ENG-PUDSP22001-R1-GEC.pdf Markup Summary

PUDSP221

FOREBAY NO. 1 SECTION A-A  
NO SCALE

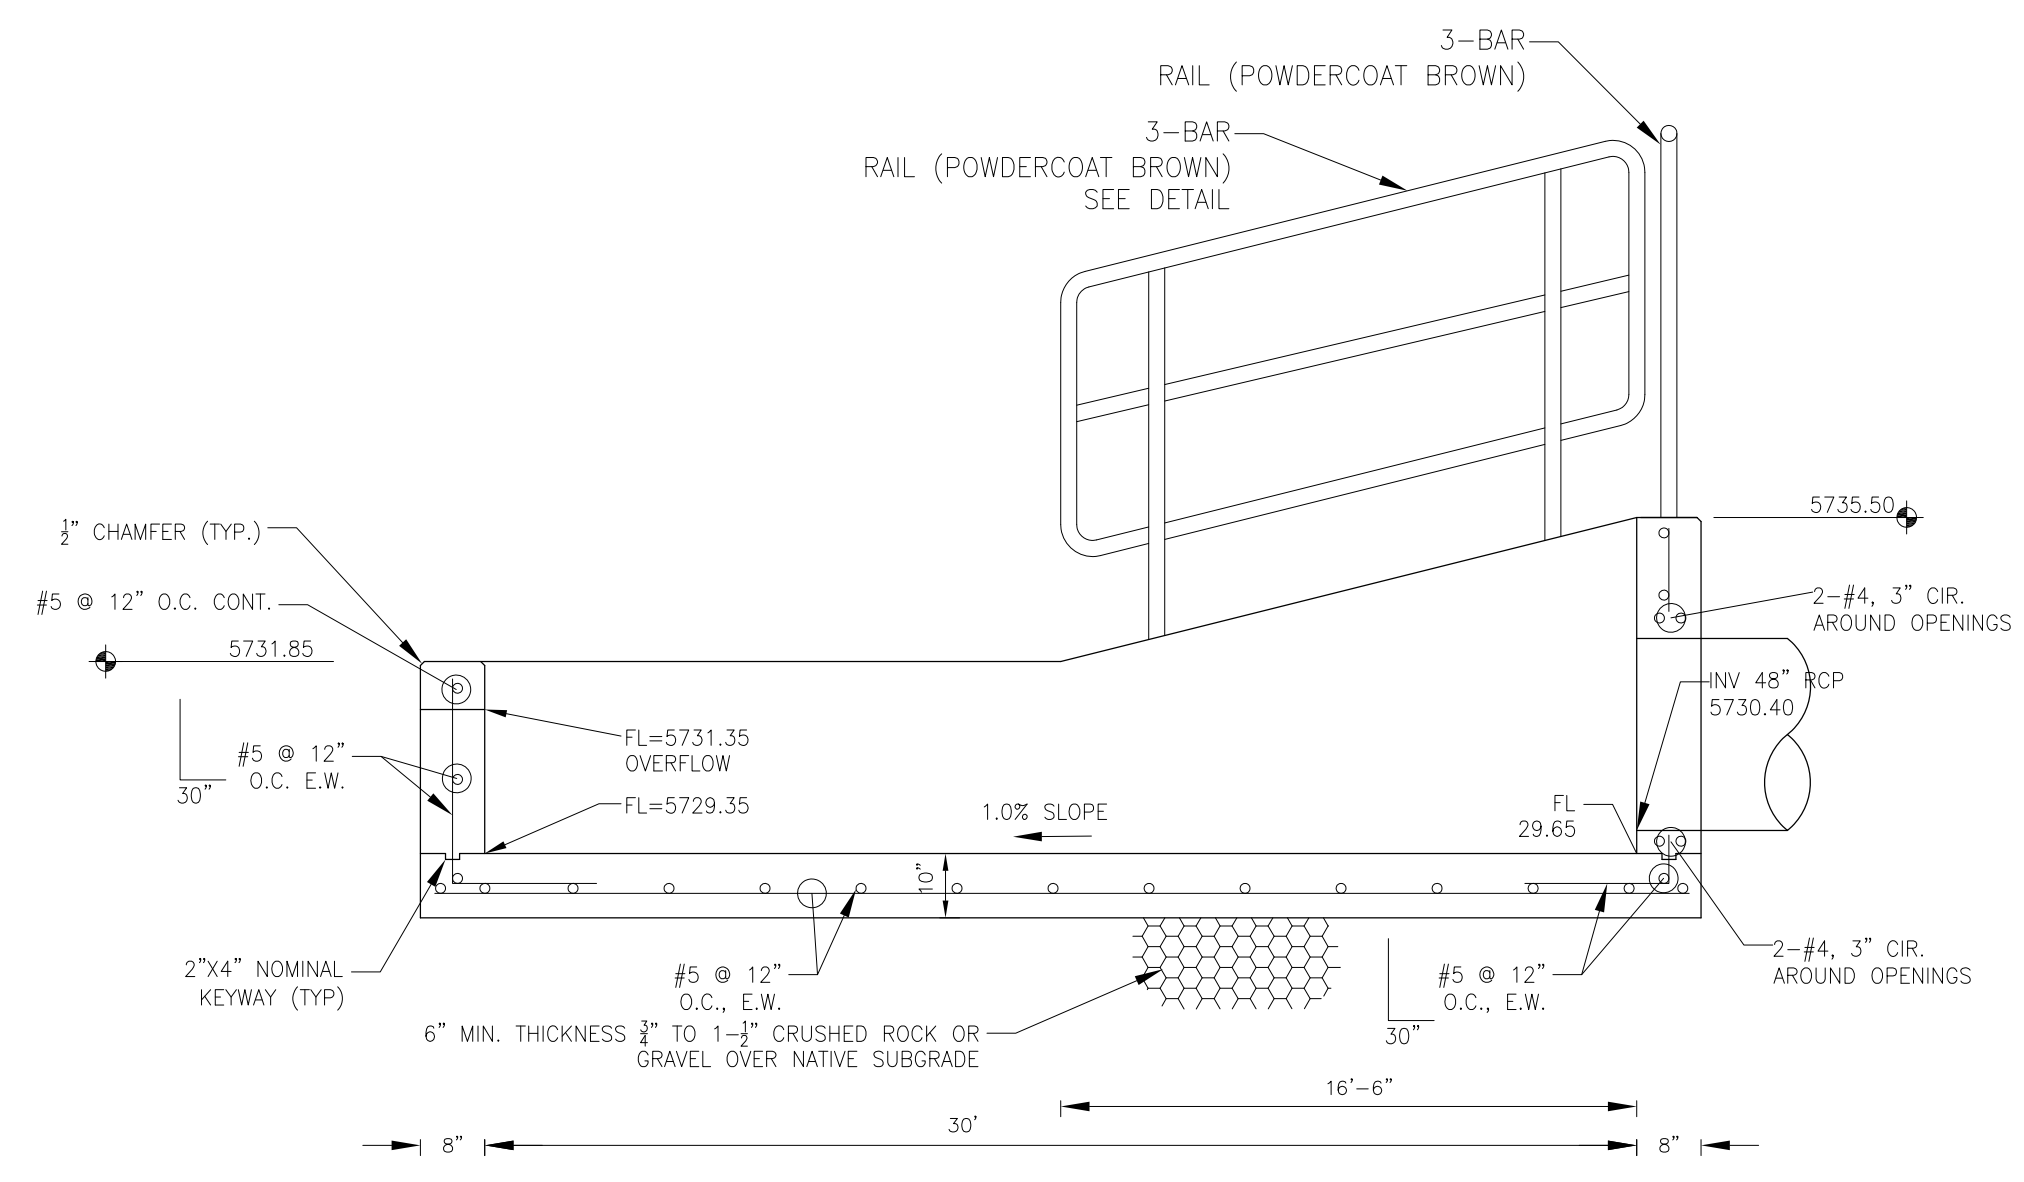
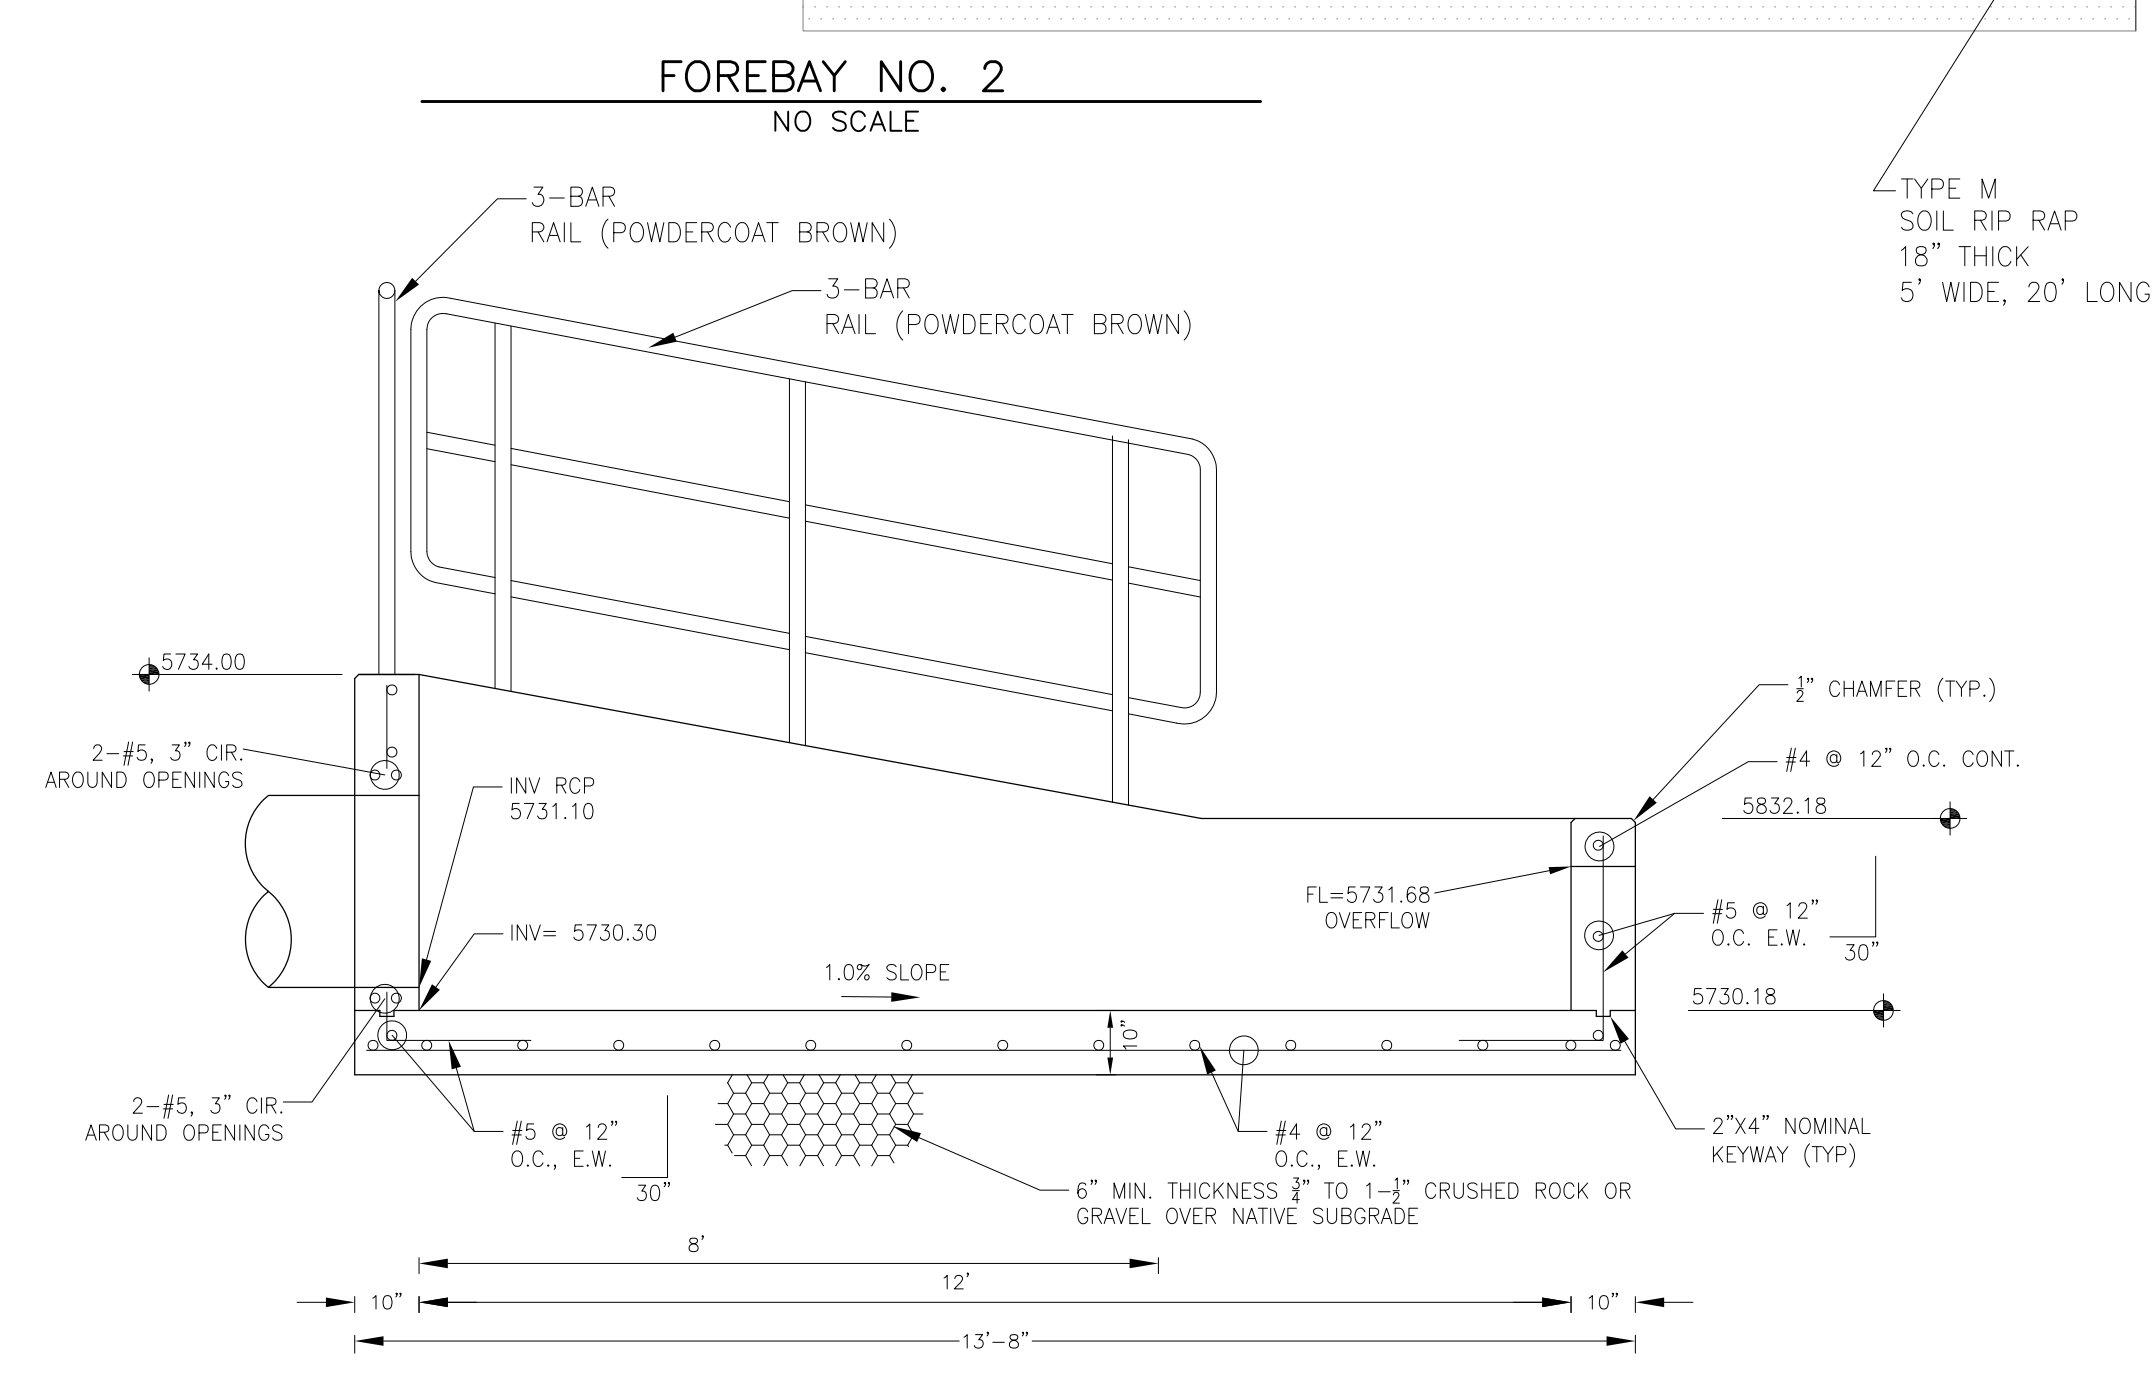
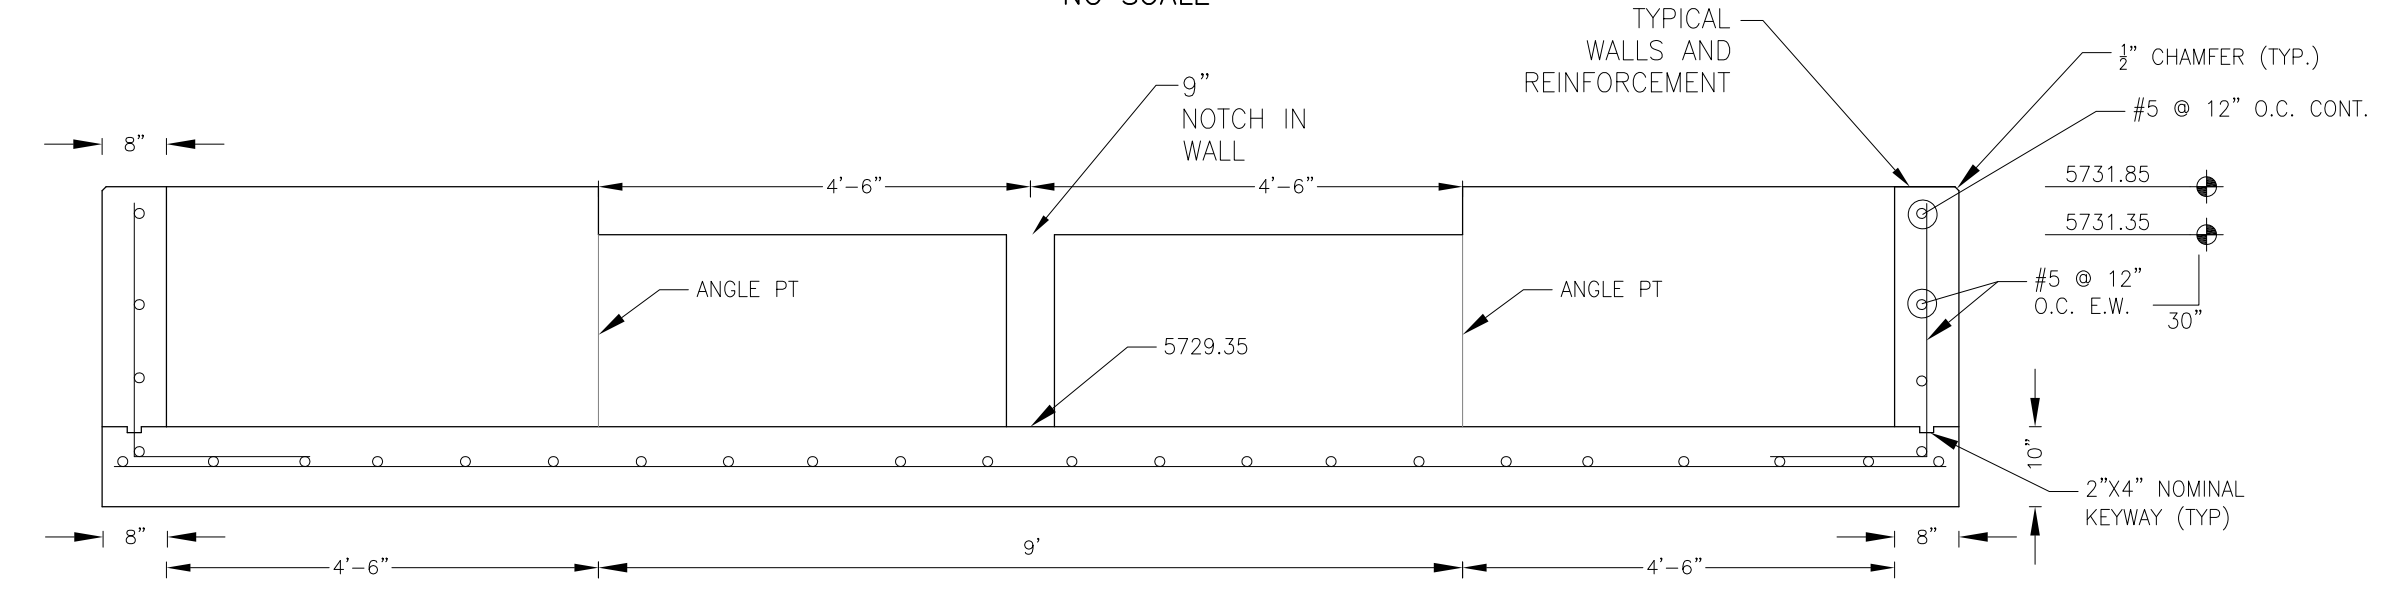
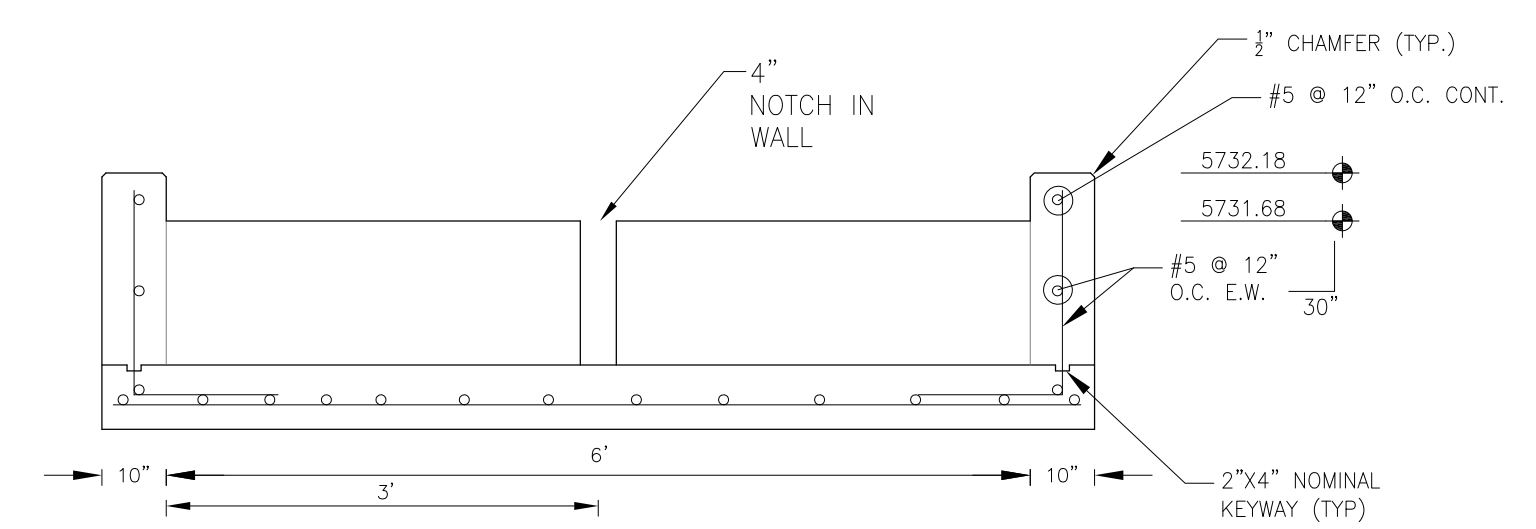
Per pdf pg 113 in PDR, this should be 9.5". But the 9.5" shown on that page is for if there was only one forebay for the whole pond. So you will need to show separate calcs for each forebay to determine notch size and volume for each.

double check volume calcs for the combined two forebays that they meet the min volume req's shown on pdf pg 113 of PDR.

show calcs for this notch in the FDR for final plat.
